Our ref: RA/2020/142307/01-L01
Your ref: 2020/91474
Date: 13 November 2020

**FORMATION OF 55 SPACE CAR PARK WITH ASSOCIATED WORKS – FORMER
SCRAP YARD, ADJ CANALSIDE WEST, FIRTH STREET, HUDDERSFIELD, HD1
3DB**

Project Number	Building	Drawing	Revision
MW 2020 024	B	001

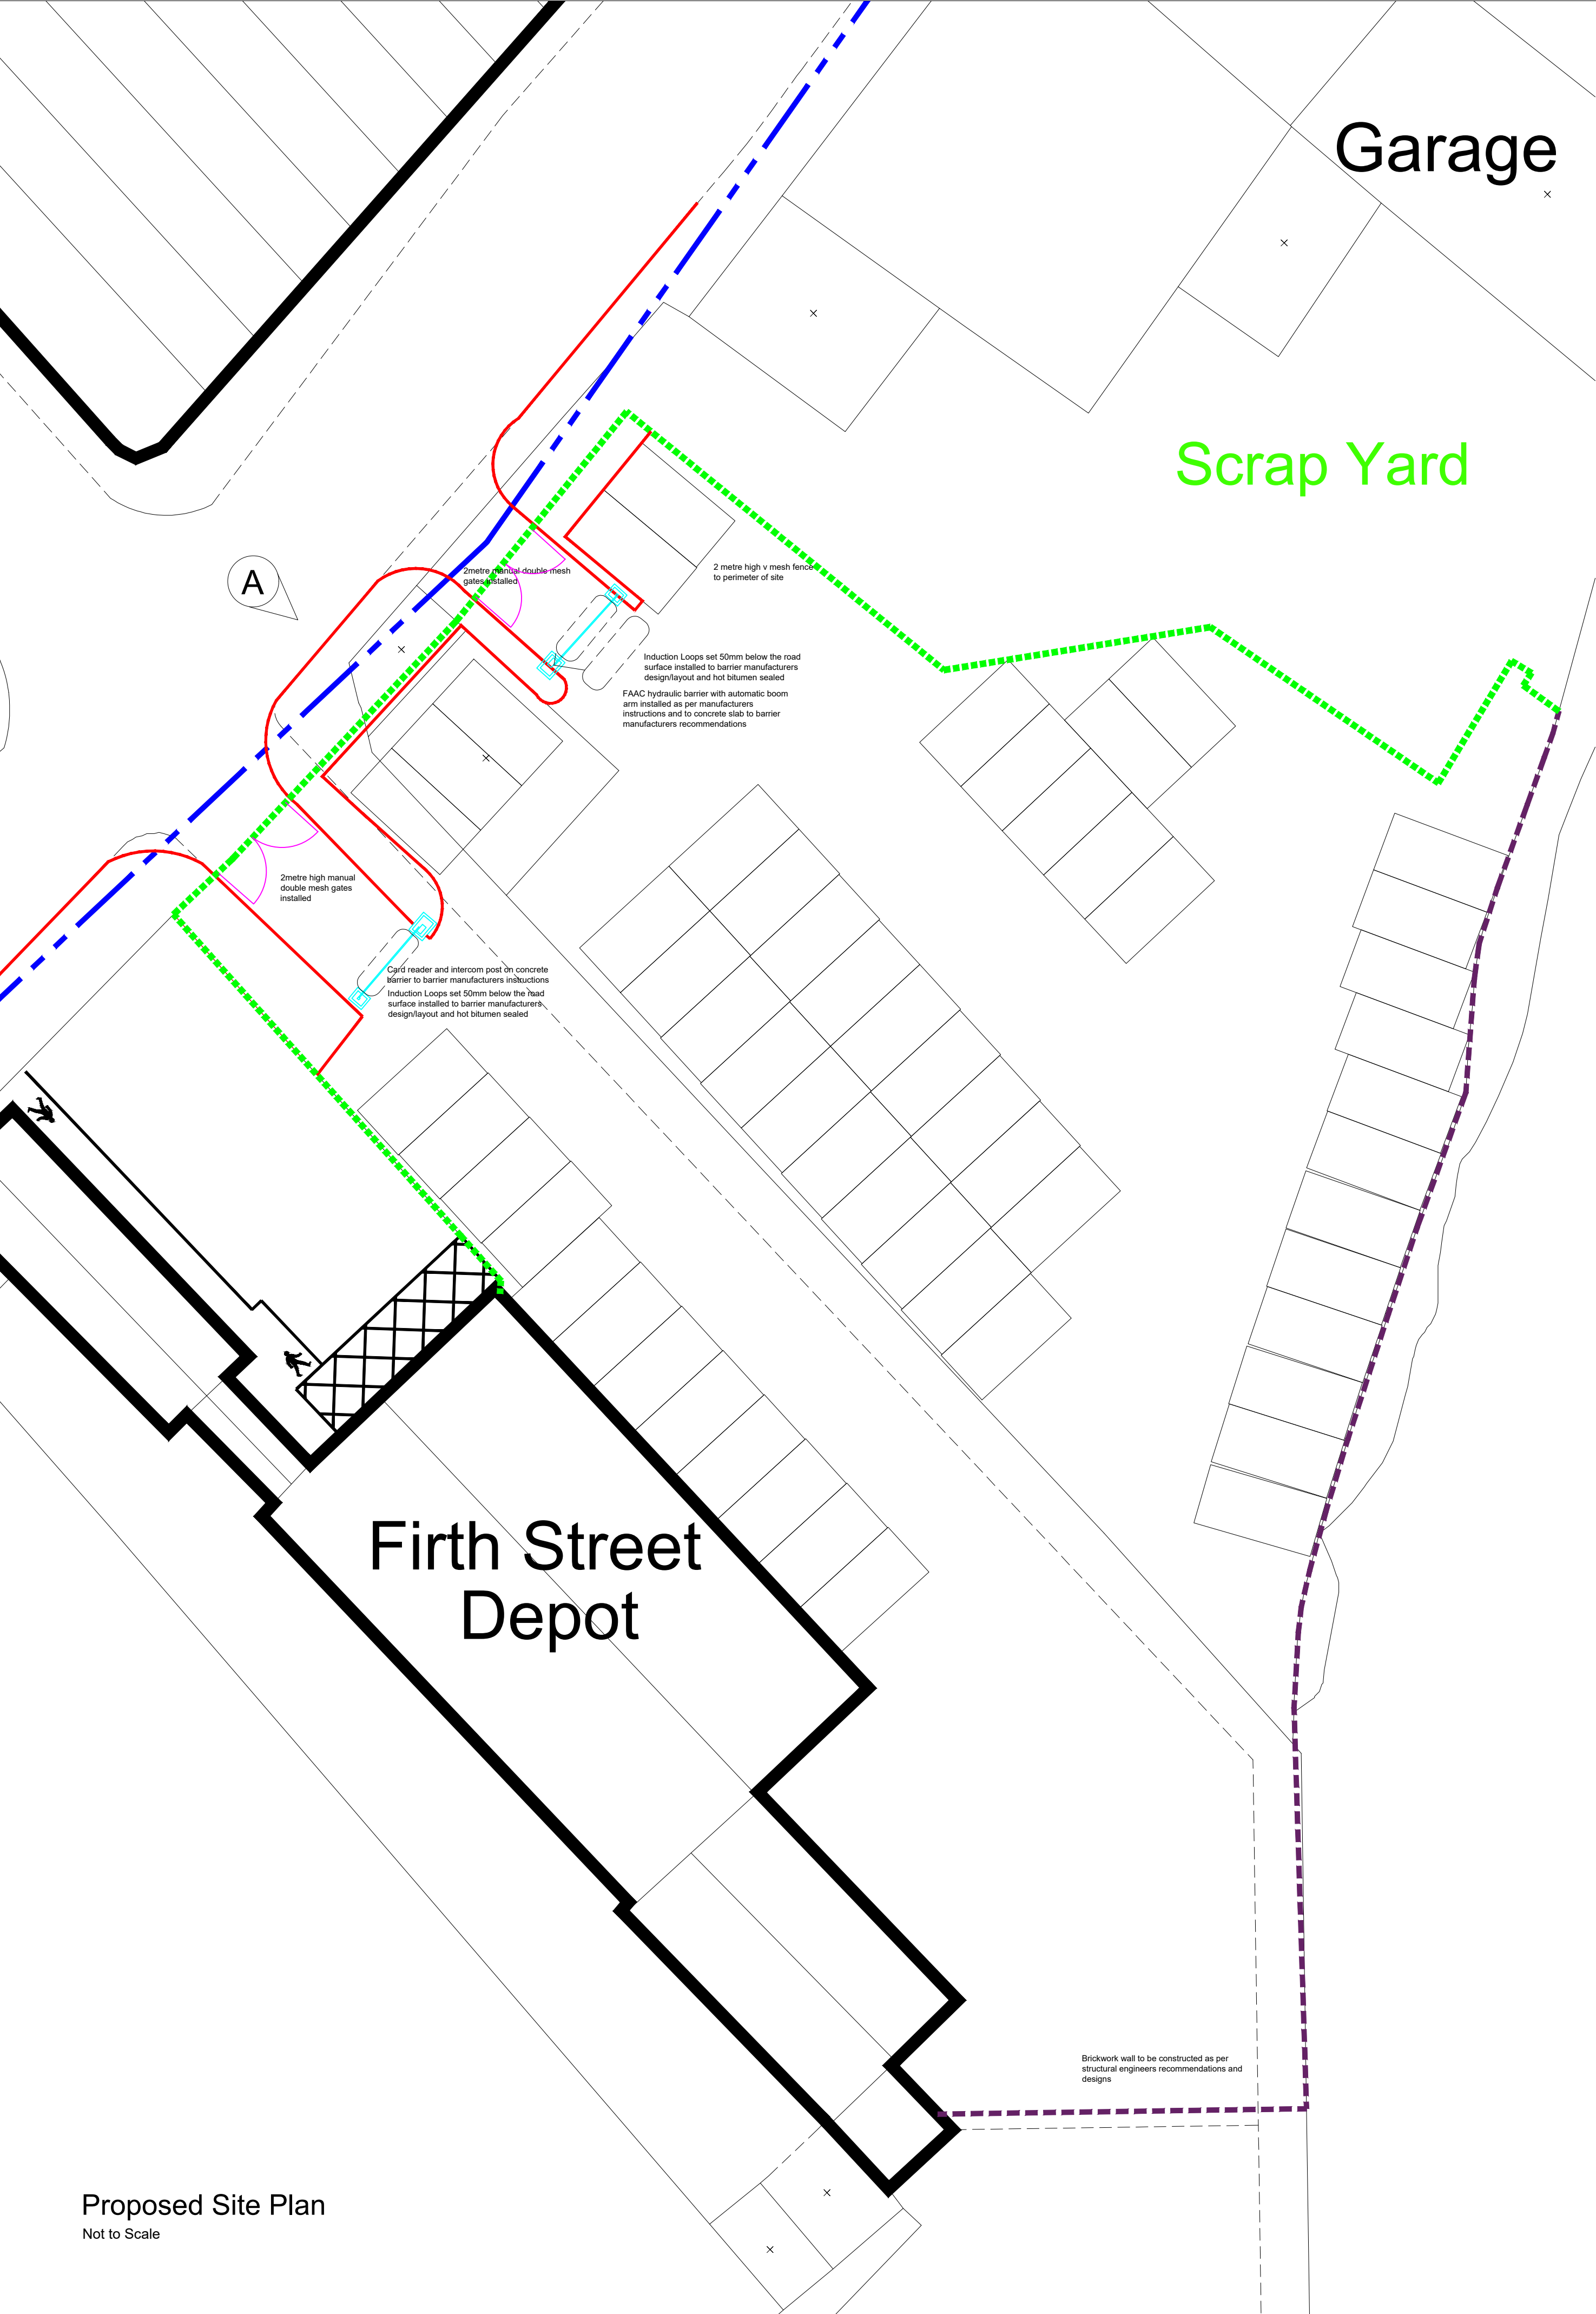
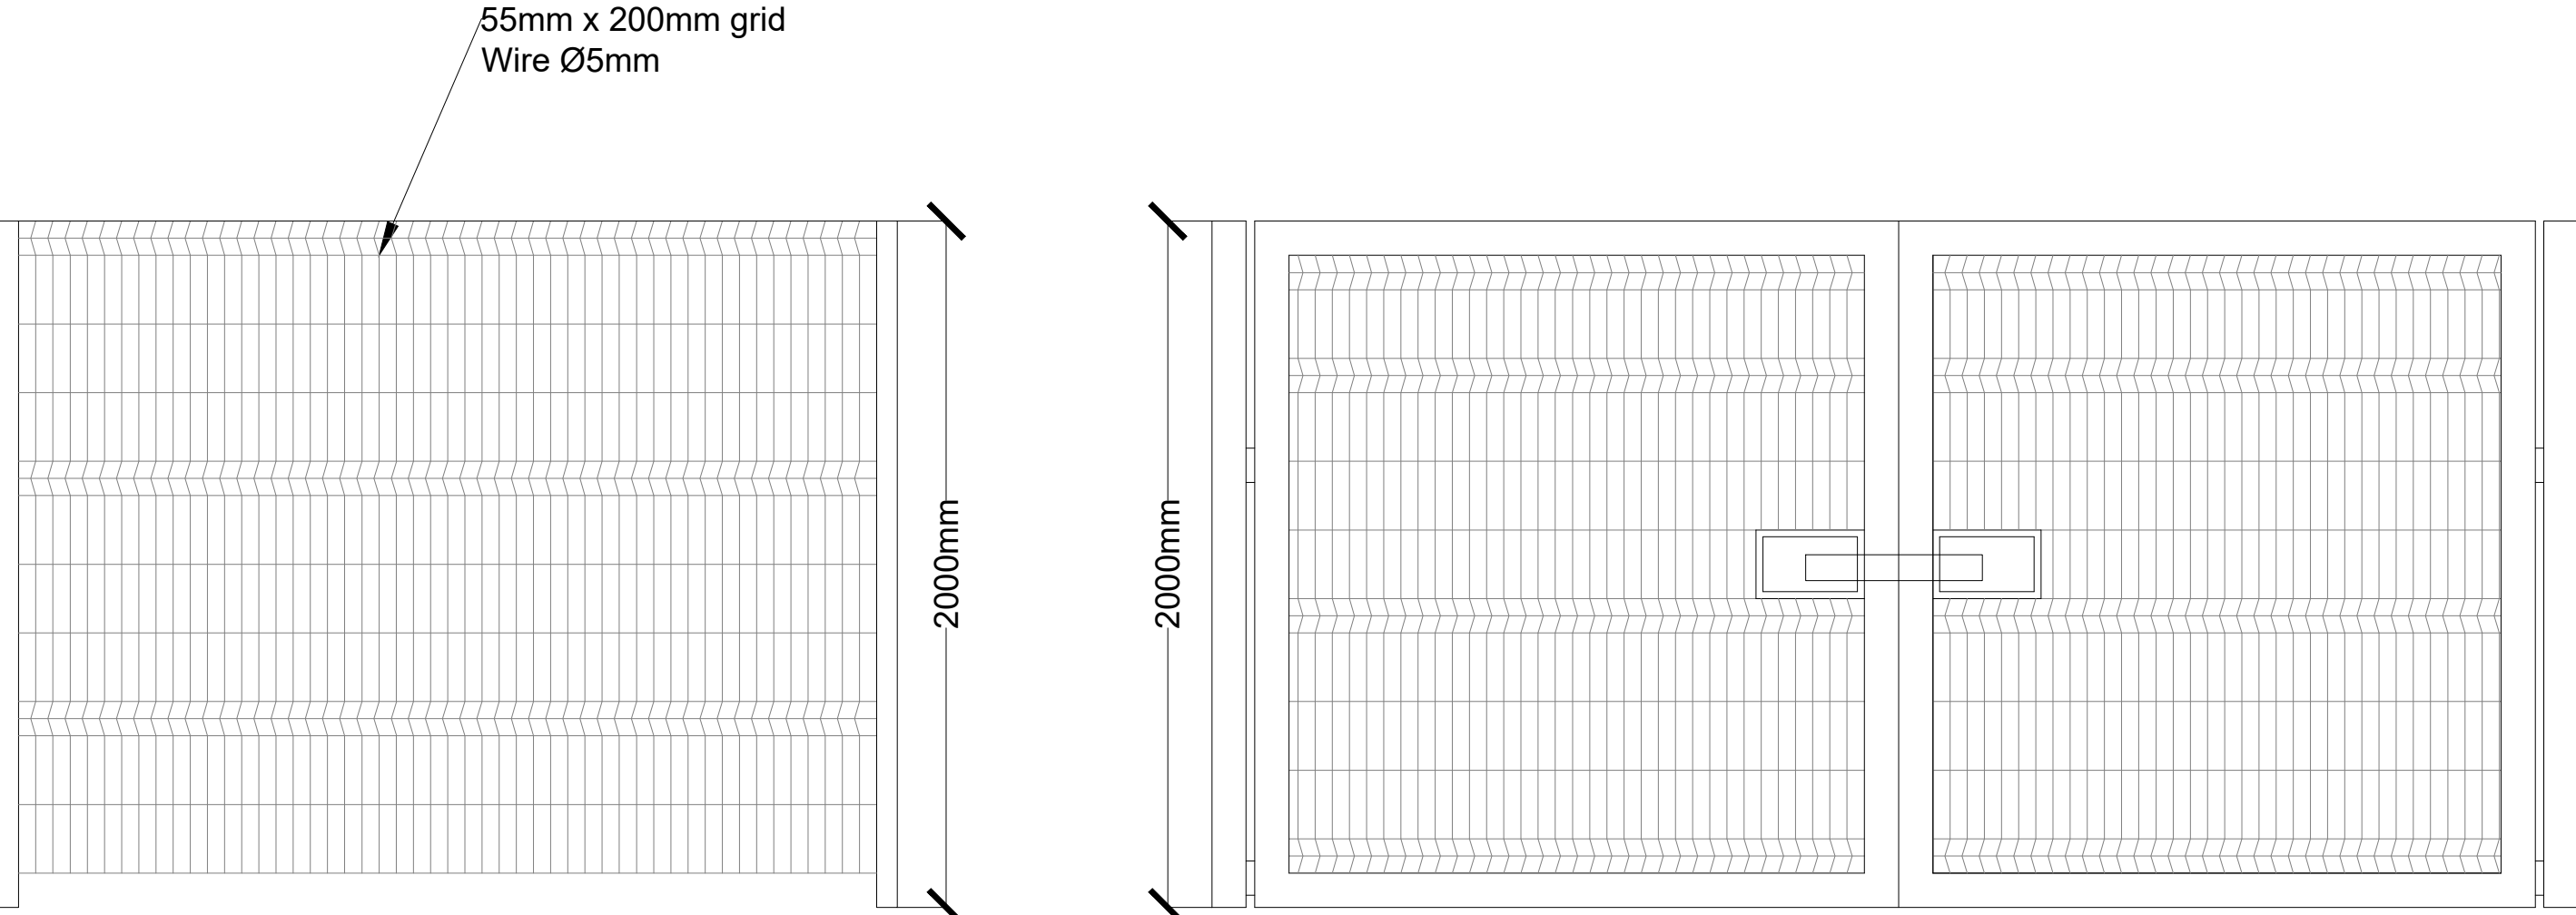
We note drawing number MW 2020 024 B 001 dated 07.04.2020 shows a proposed wall running down the eastern boundary of the site, and there is reference to installing

An Environmental Permit for a Flood Risk Activity will be required for any structures, such as walls, fences, bollards and outfall structures, which are within 8 metres of the bank of the River Colne.

We require a minimum 3 metre easement from the bank of the River Colne to allow us access to the river for maintenance purposes and any future works we may plan in this area.
